**KIRKLEES METROPOLITAN COUNCIL
INVESTMENT & REGENERATION SERVICE**

**DELEGATED DECISION TO DETERMINE APPLICATIONS FOR
CONSENT, AGREEMENT OR APPROVAL REQUIRED BY CONDITION**

Reference No:	2024/44/93041/E
Site Address:	The Old Tannery, 224, Spen Lane, Gomersal, BD19 4PJ
Description:	Discharge of details reserved by condition 11 (validation report) on previous permission 2021/92255 for erection of 5 dwellings with associated access and demolition of existing extensions to commercial building
Recommending Officer:	Elenya Jackson

DECISION – Discharge of Condition 11 - Refused

Photographs

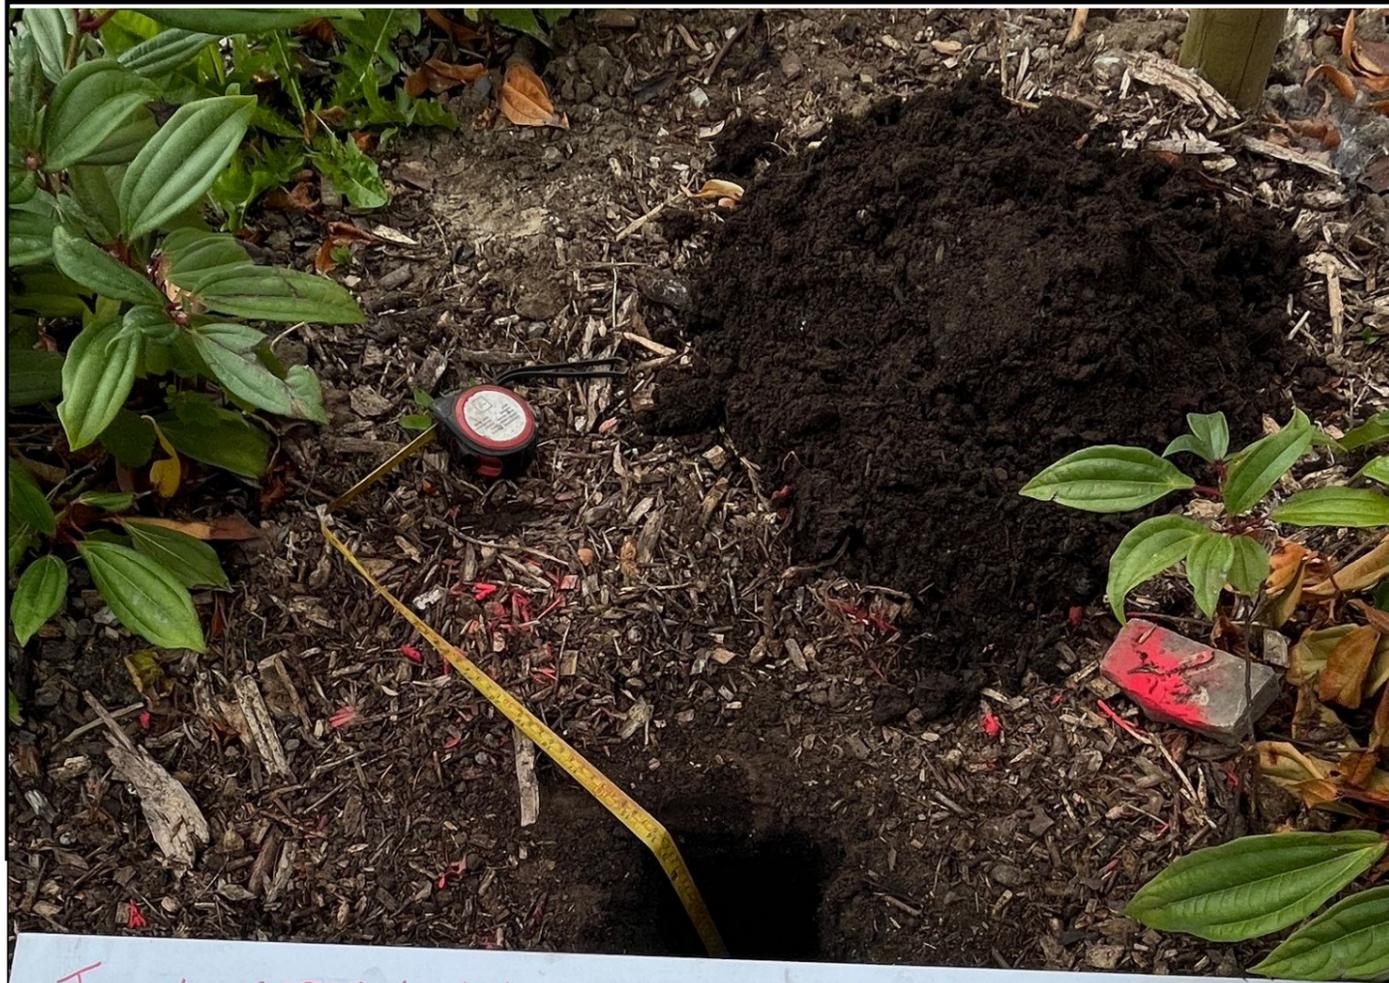
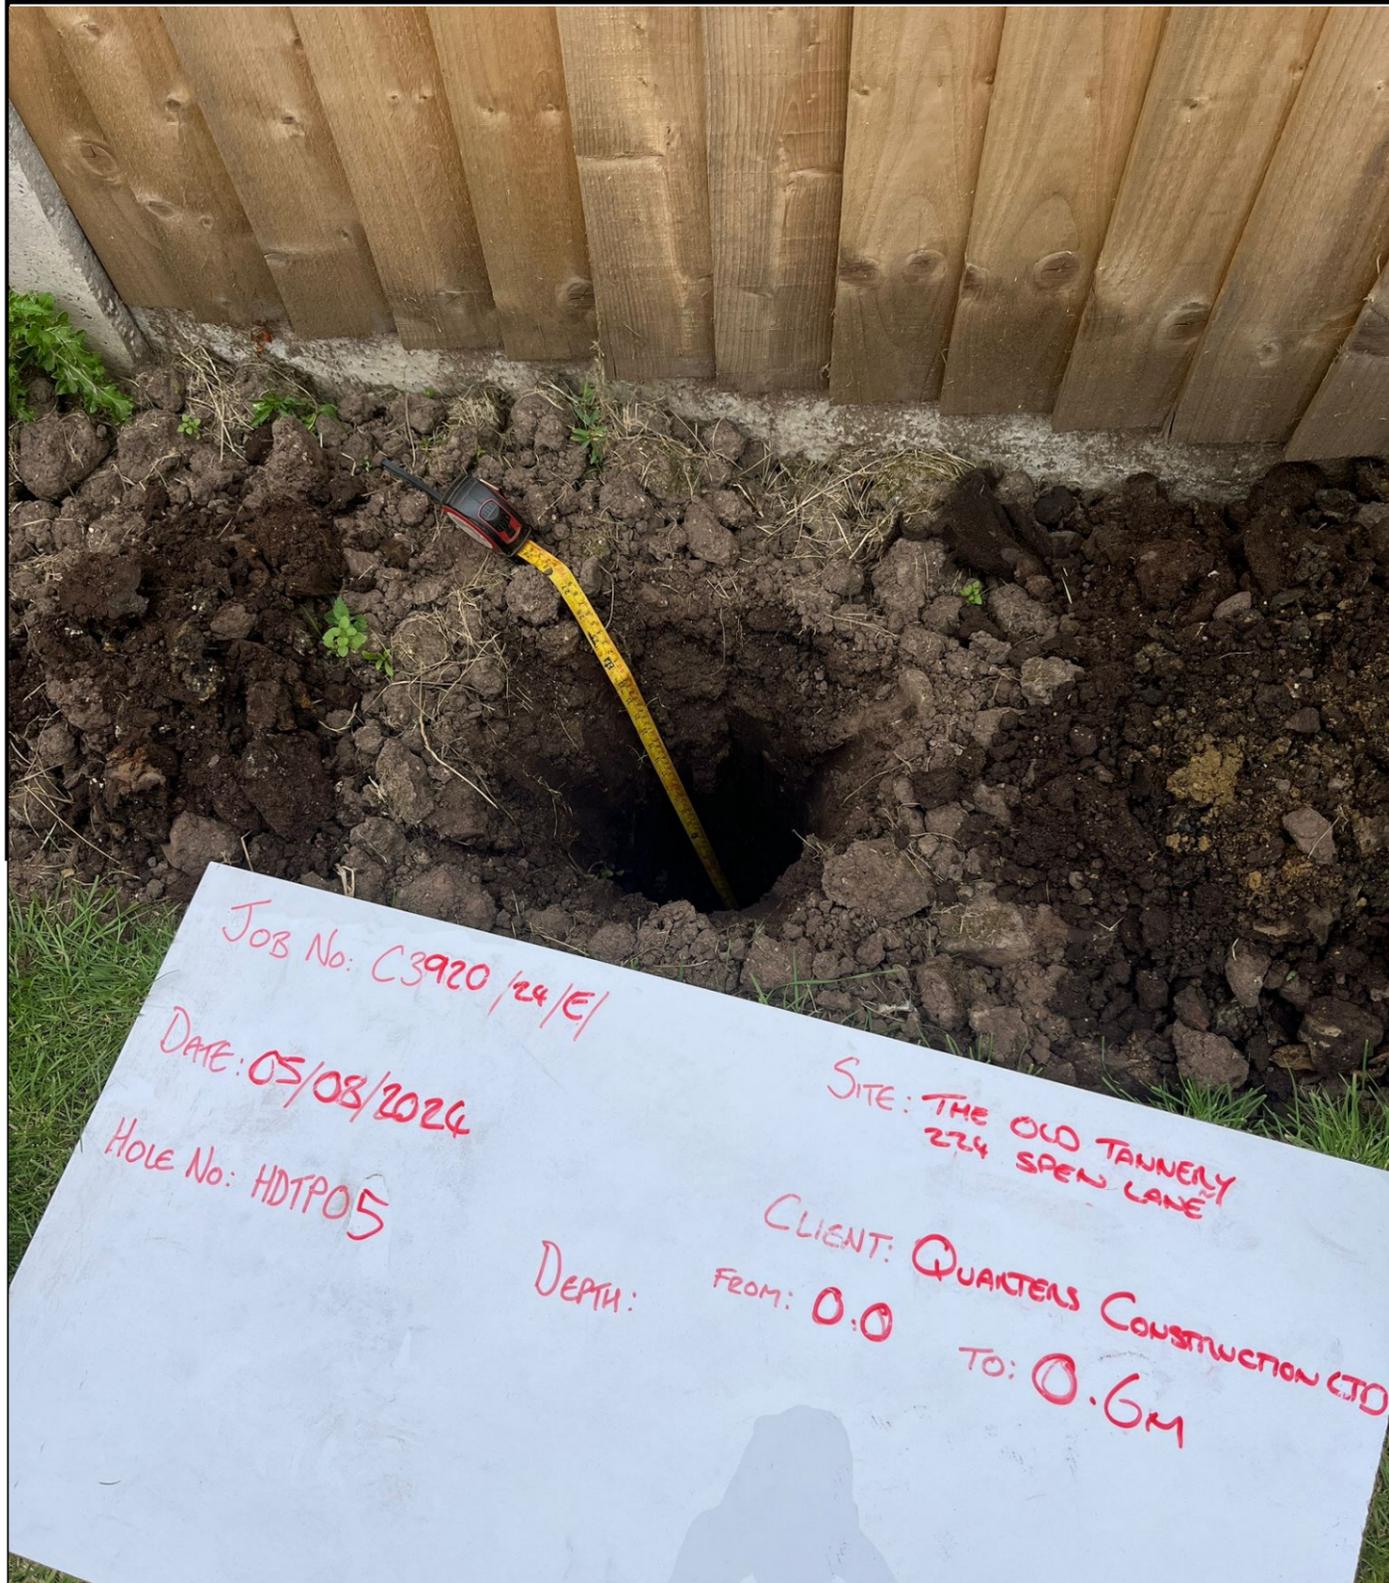
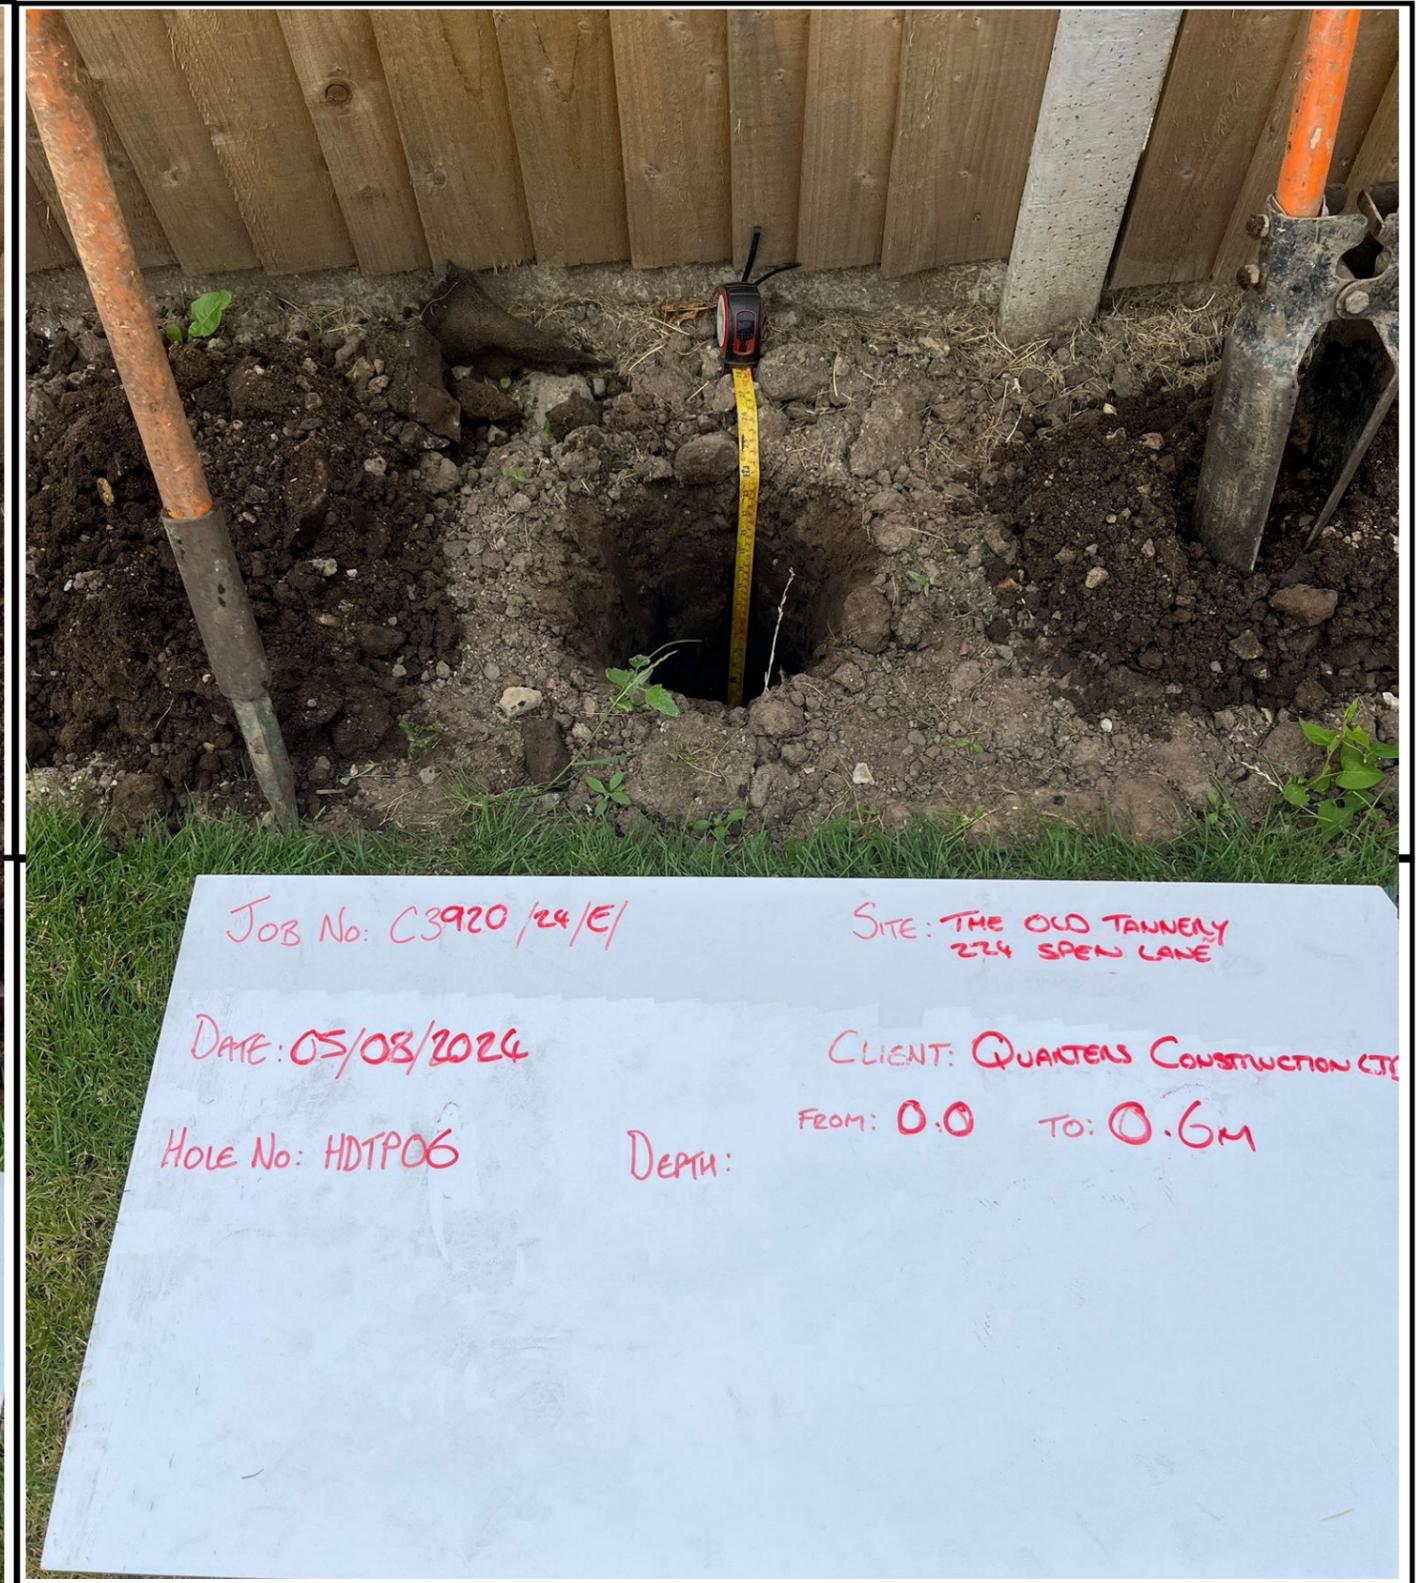
- The agreed clean cover system included a geotextile membrane. However, no membrane is reported in the trial pit logs or evidenced in the photographs. Further clarification on this point is necessary.
